City of Albuquerque

RE: SADLER MINI STORAGE (D-18/D39)
(7801 Louisiana NE)
ENGINEERS CERTIFICATION FOR CERTIFICATE OF OCCUPANCY
ENGINEERS STAMP DATED 2/2/2000
ENGINEERS CERTIFICATION DATED 5/3/2001

RE: SADLER MINI-STORAGE (D18-D39). GRADING AND DRAINAGE PLAN FOR BUILDING PERMIT AND SO#19 PERMIT APPROVALS. ENGINEER'S STAMP DATED AUGUST 9, 1999. SUPPLEMENTAL DATA LETTER DATED OCTOBER 4, 1999.

RE: SADLER MINI-STORAGE (D18-D39). GRADING AND DRAINAGE PLAN FOR BUILDING PERMIT AND SO#19 PERMIT APPROVALS. ENGINEER'S STAMP DATED FEBRUARY 2, 2000.

REV.	DATE	DESCRIPTION
PROJECT TITLE Sadler Mini--Storage		
Location at Ranchitos Albuquerque, NM		
SHEET TITLE Drainage Plan		
DRAWN BY REH		
CHK'D BY REH		
DATE: 08/03/99		
C1

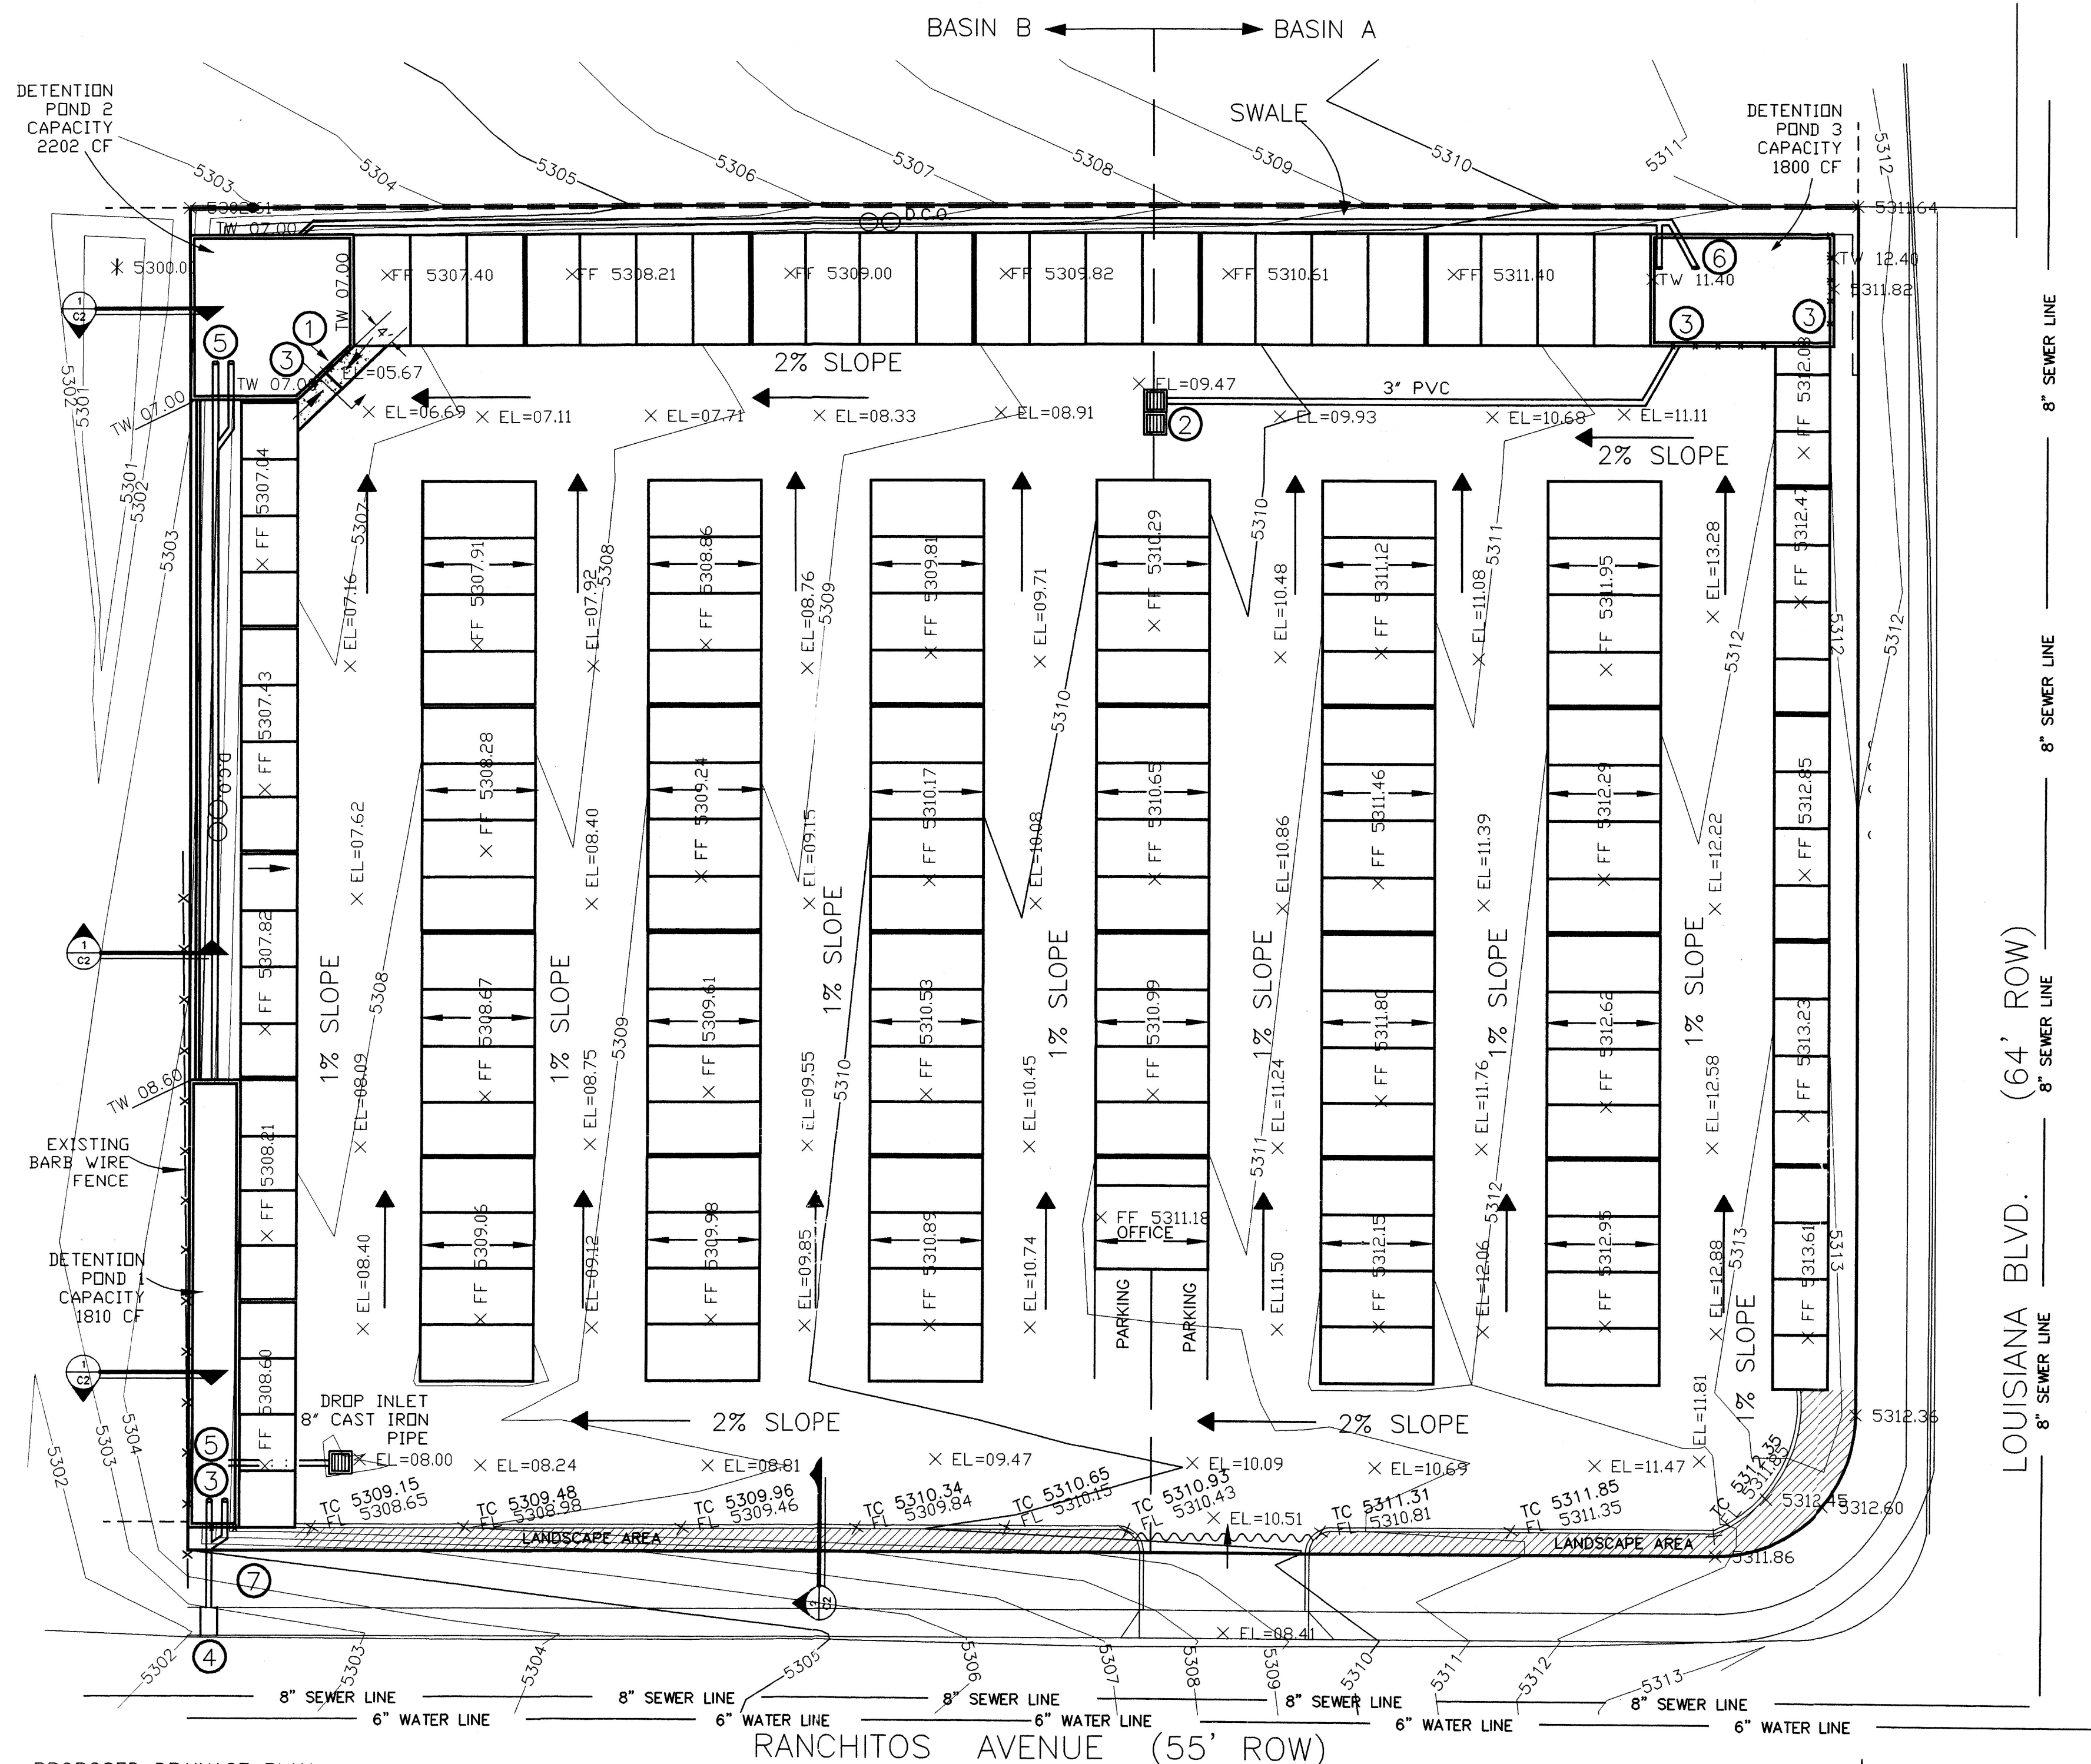
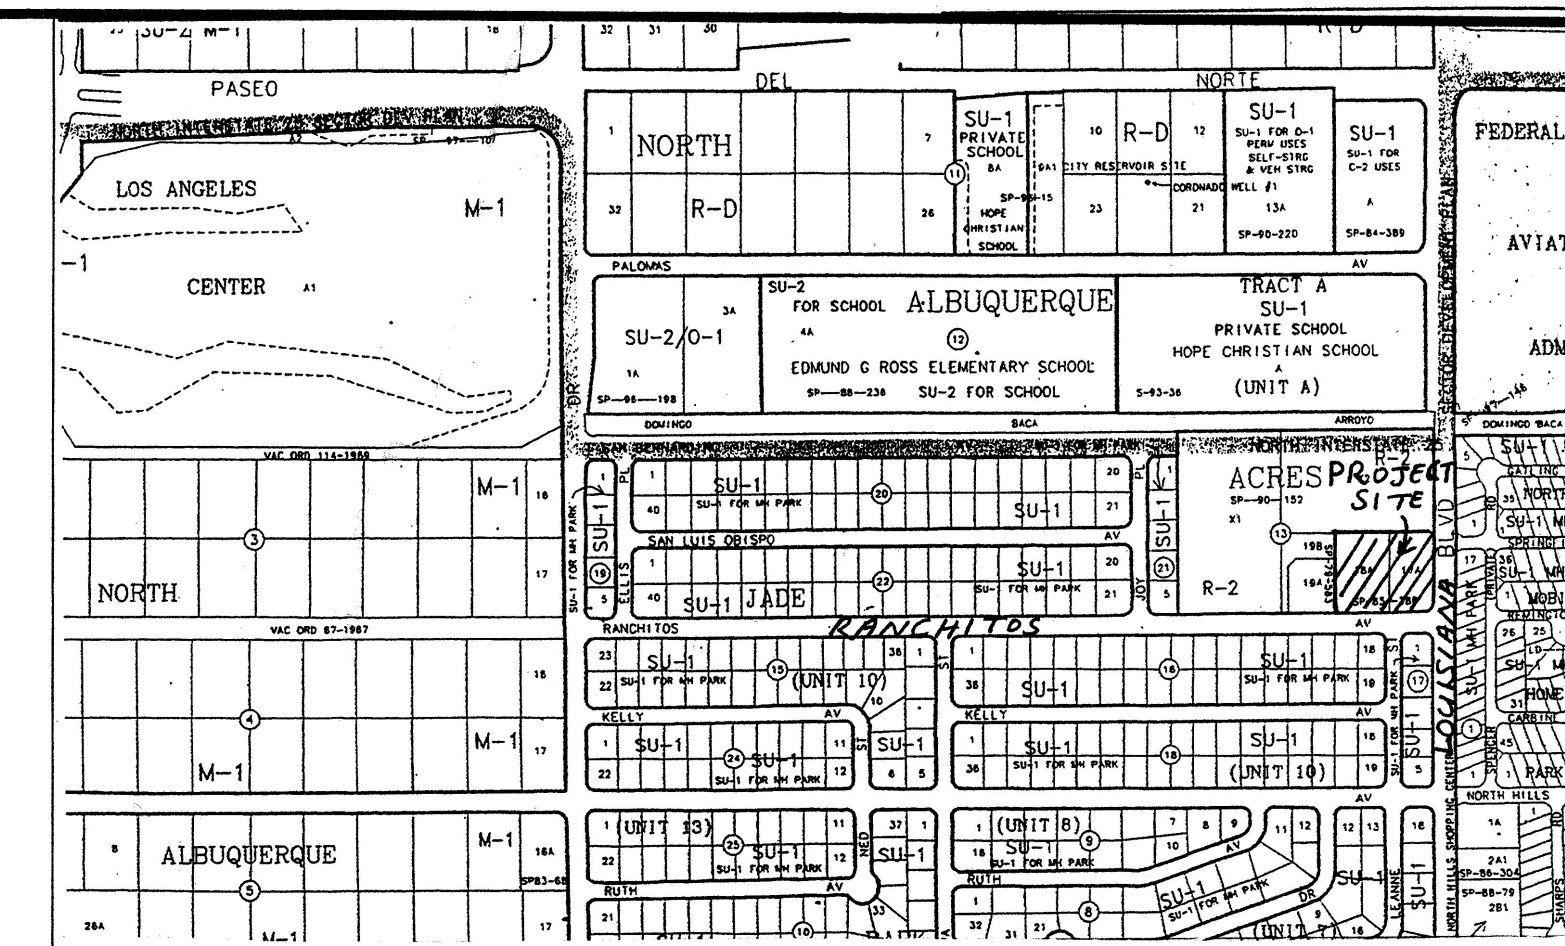
This submittal rotated the storage units 90-degrees. The buildings now run North-South with drainage discharging to Ranchitos Ave. rather than Louisiana Blvd. hence the request for an evaluation of the downstream capacity. (An interim plan would have required an easement through the Louisiana Purchase (Condos).

REV.	DATE	DESCRIPTION
1	02/28/00	PROJECT TITLE: Sadler Mini-Storage Louisiana at Ranchitos Albuquerque, NM
2	02/28/00	SHEET TITLE: Drainage Plan
3	02/28/00	DRAWN BY: [Signature]
4	02/28/00	CHK'D BY: [Signature]
5	02/28/00	DATE: 02/28/00
6	02/28/00	D1

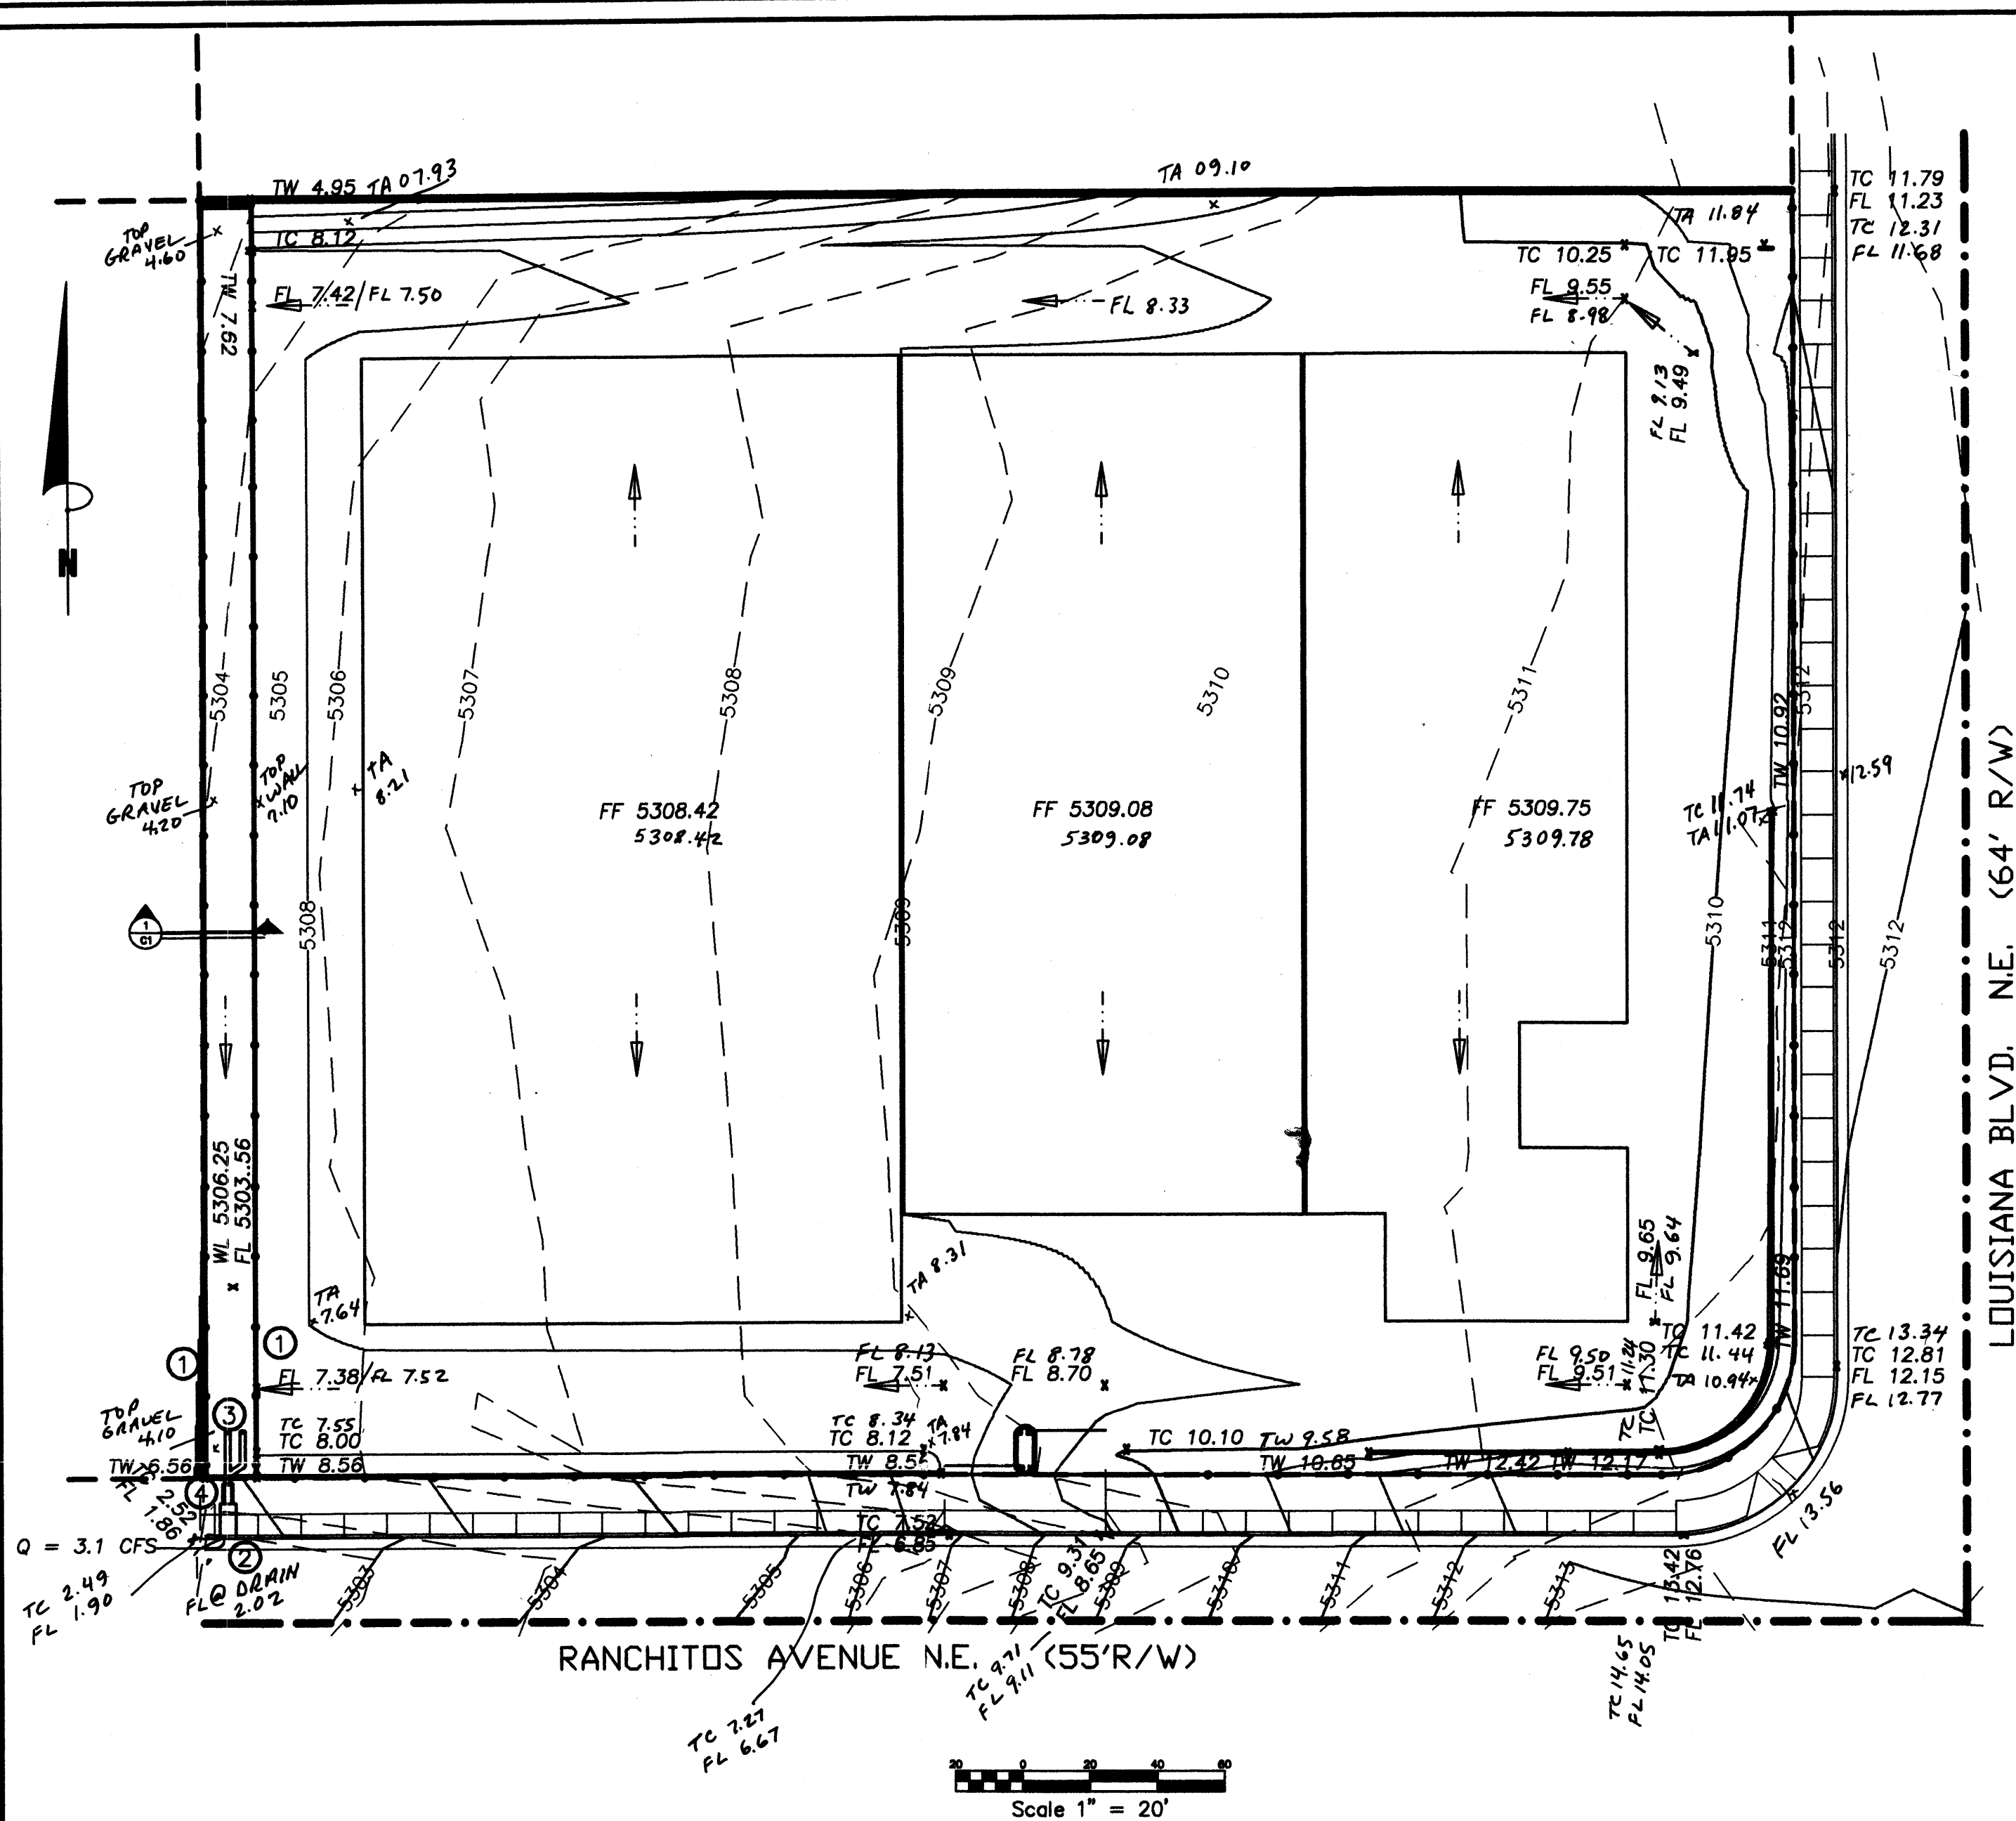
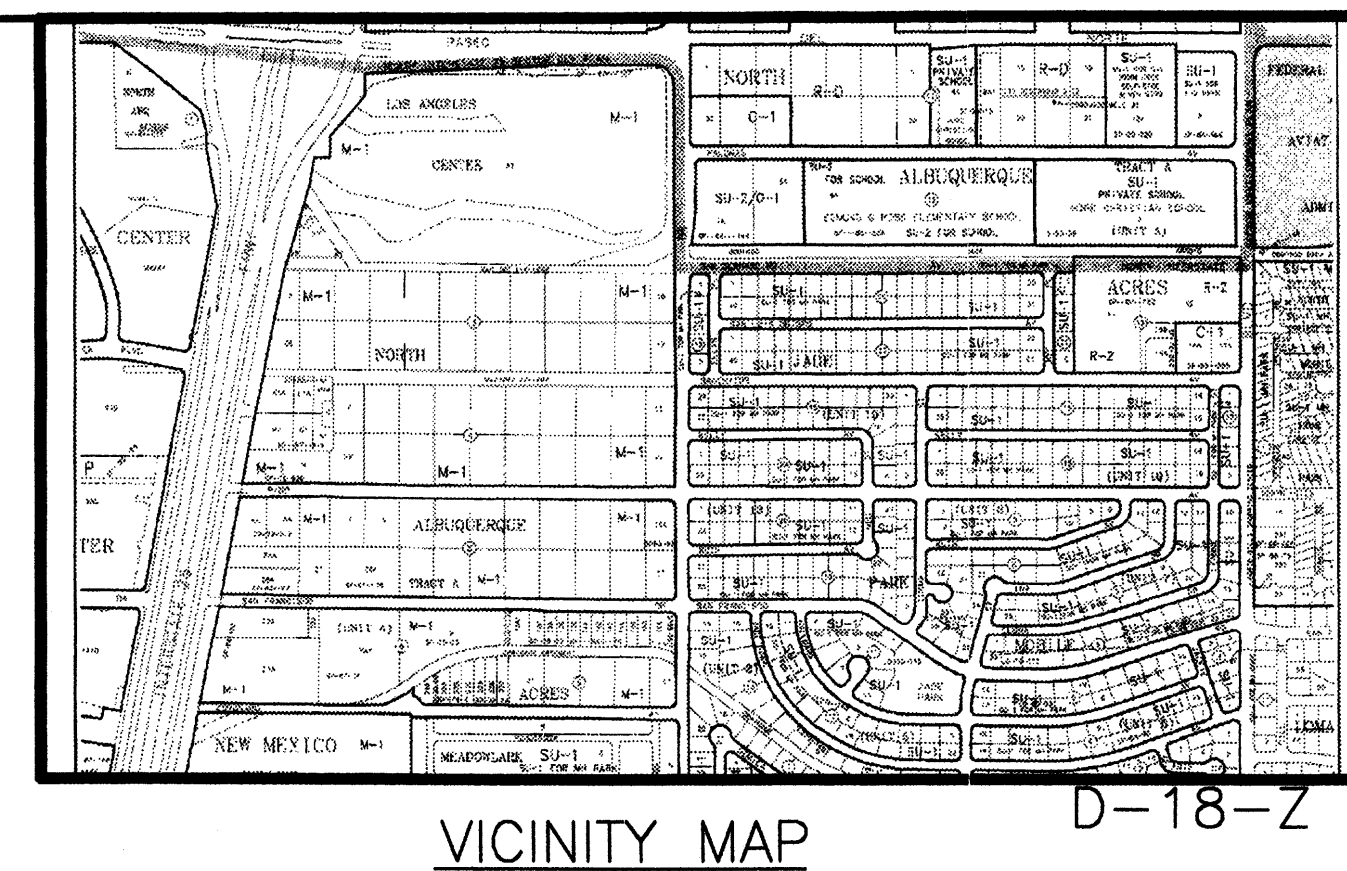
Based on the information provided on your February 9, 2000 submittal, the above referenced project is approved for Building Permit and for SO#19 Permit. The facility has been completely reconfigured since the previous submittal of August/October 1999. Indicate the direction(s) of the roof drainage. Show outlet control calculations. Clarify language regarding detention pond(s).
